From: [Cruse & Associates](#)
To: [Dusty Pilkington](#)
Cc: [Roger Weber](#); [Jim Miller](#)
Subject: Fw: Fwd: BL-17-00012 Miller
Date: Monday, August 07, 2017 11:14:30 AM
Attachments: [Revised App.pdf](#)

From: **Dusty Pilkington** <dusty.pilkington@co.kittitas.wa.us>
Date: Thu, Aug 3, 2017 at 4:36 PM
Subject: BL-17-00012 Miller
To: "rogweb100@gmail.com" <rogweb100@gmail.com>, "jt_miller@msn.com" <jt_miller@msn.com>

I have begun the initial review of the Boundary Line Adjustment application on parcels 310836, 150836, and 450236. As it is proposed, we may not be able to process the BLA. Kittitas County Code 16.10.010:

# MILLERWEBER EXISTING PARCELS

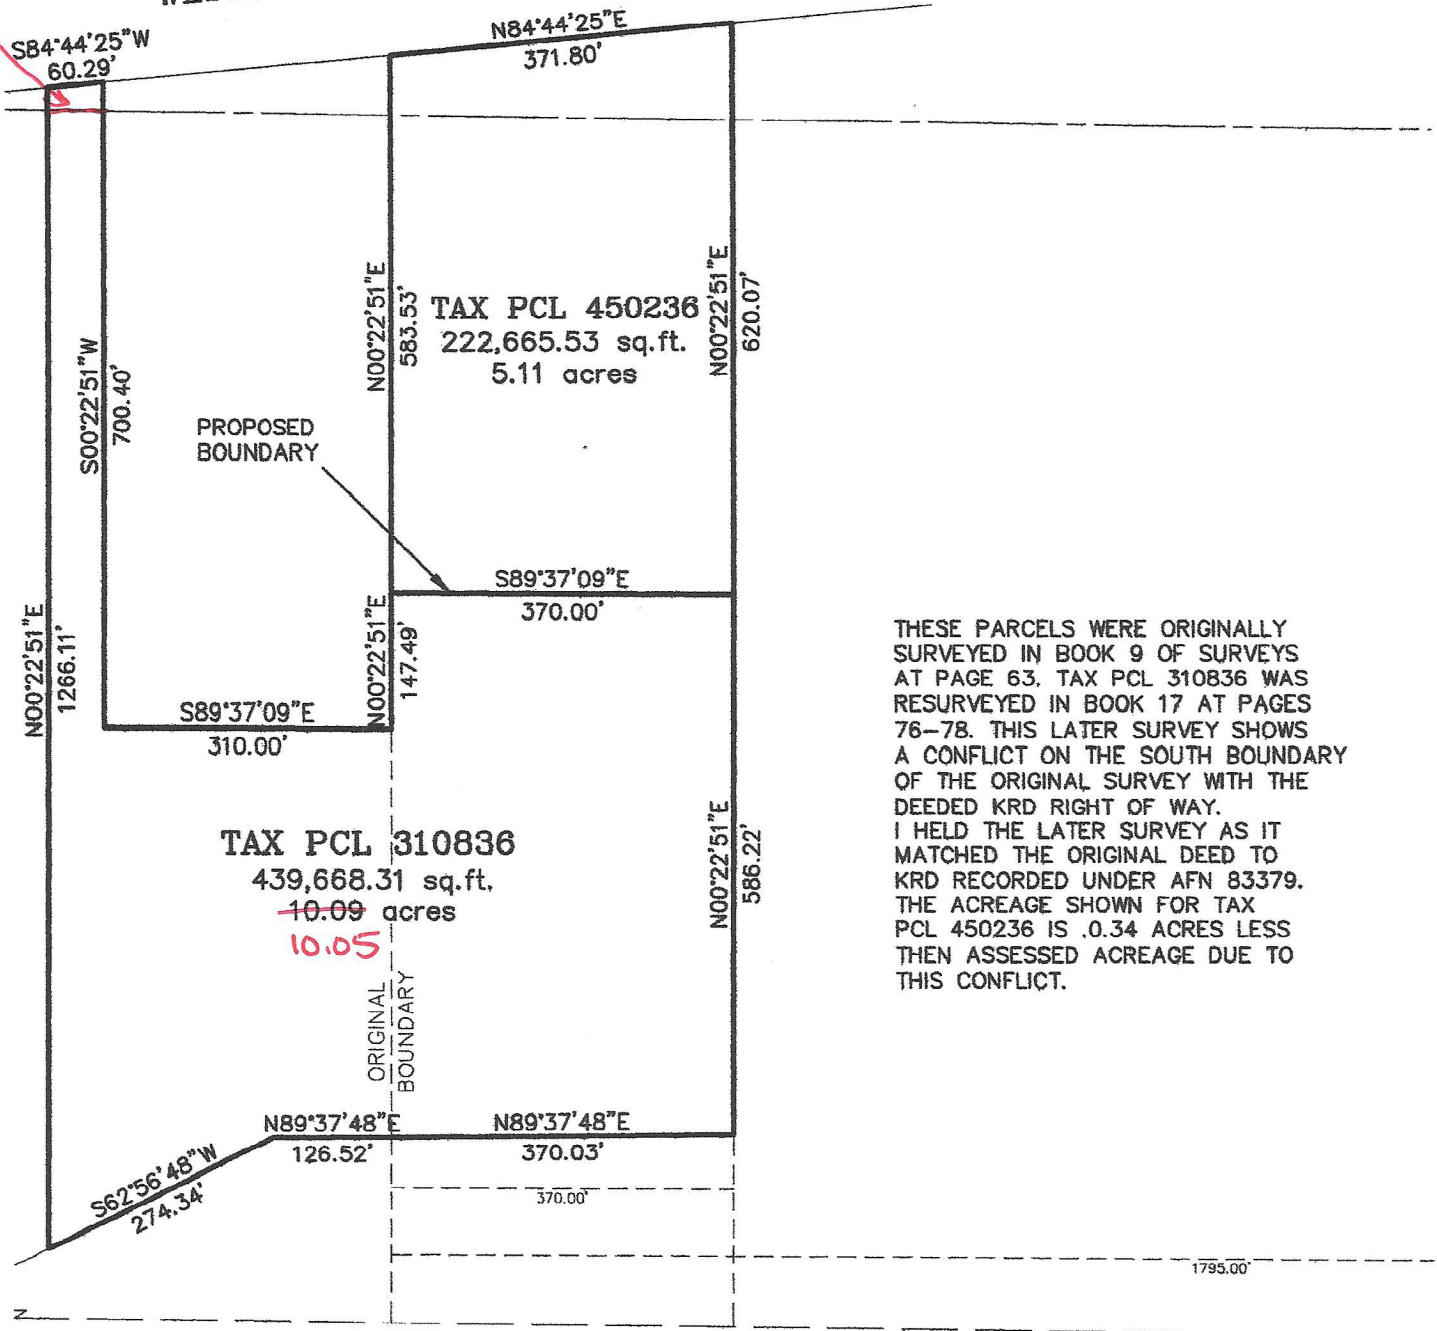
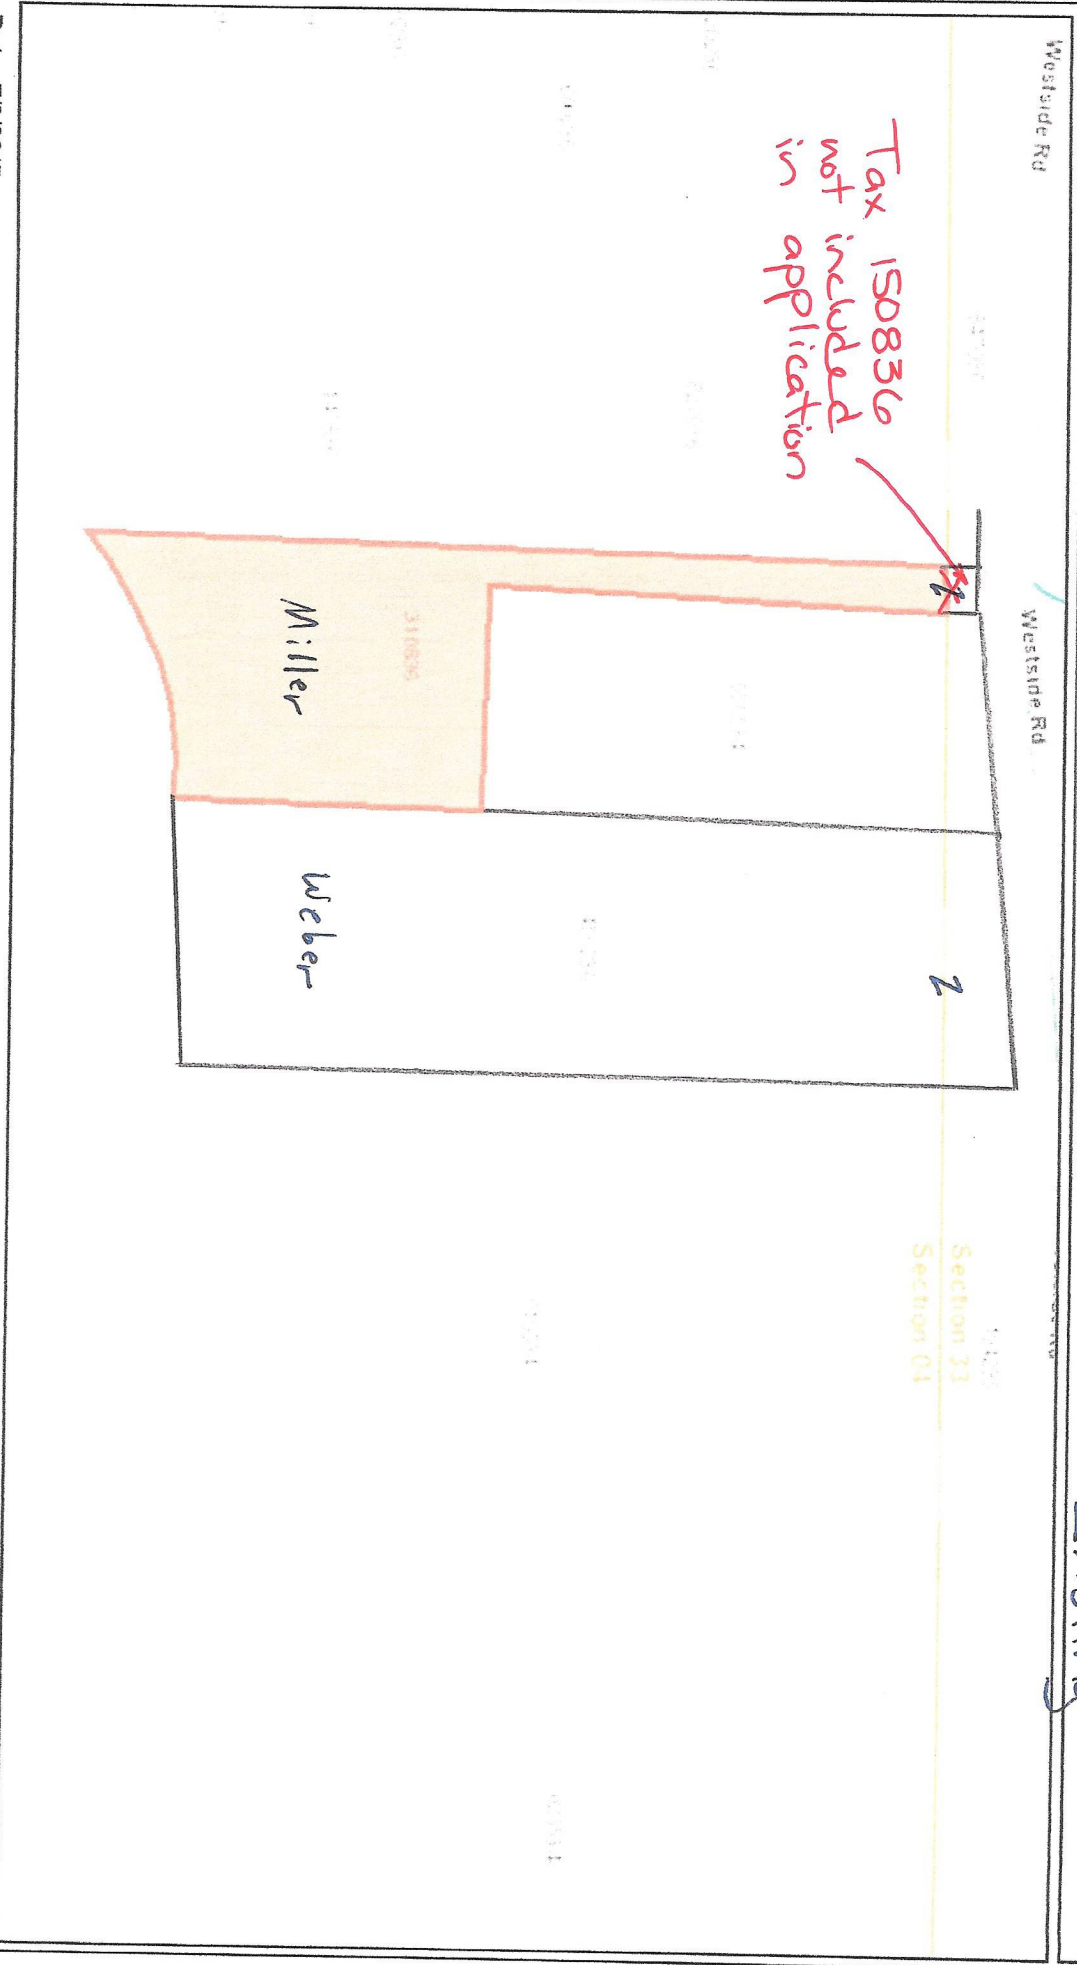
The northern 0.04 acre parcel, number 150836, is entirely within the Agriculture 5 zone, while the parcel to the south, 310836, is within the Rural 5 zone. Eliminating the boundary would create a split zoned parcel. In order to be compliant with County Code, the proposed boundary lines must be redrawn such that all parcels created are within the same zoning district.

Dusty – Just talked to Kathy Weber regarding the below email. The split zoning is an existing condition and this application is not creating any split zoning or combining parcels. We typically list (MBSW) parcels so all departments know the ownership boundary but how about we simply remove tax 150836 from the application. The split zoning tax parcels will be tied together (MBSW) by the Assessor but not necessary for the BLA.
